Report following a request for further information, negotiations or consultation

**REF NO:** BN/46/25/PL  
**LOCATION:** Land South of Wandleys Lane  
Eastergate  
**PROPOSAL:** Application for construction of 10 No. dwellings with new access from Wandleys Lane, landscaping and areas for ecology & amenity space. This application is a Departure from the Development Plan and is in CIL Zone 3 and is CIL Liable as new dwellings.

Following the deferral of the application at the last Planning Committee (6/8/25), a brief was issued for a review of the highways information submitted with the application and the responses received from WSCC Highways and National Highways.

Job.No:- 230010 Drg.No:- 05 Rev:- B

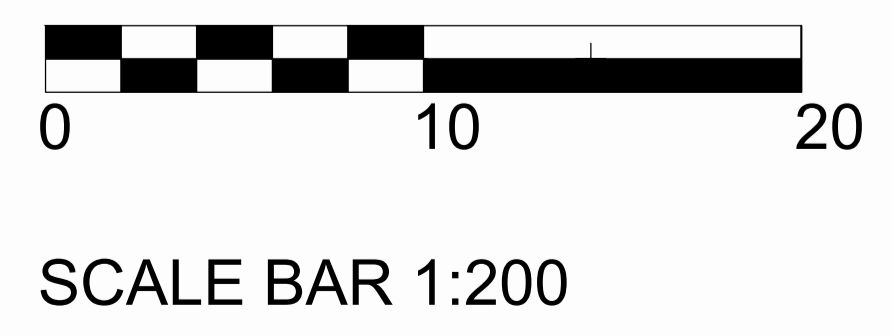
The transport consultants have highlighted a slight discrepancy regarding the necessary and demonstrated visibility splays and recommend a condition or a new plan be provided to address this. An amended plan was received and has been updated to the list of approved plans under 'Proposed Site Plan - 230010 05 B'. This shows the visibility splays at 2.4m x 43m in line with guidance.
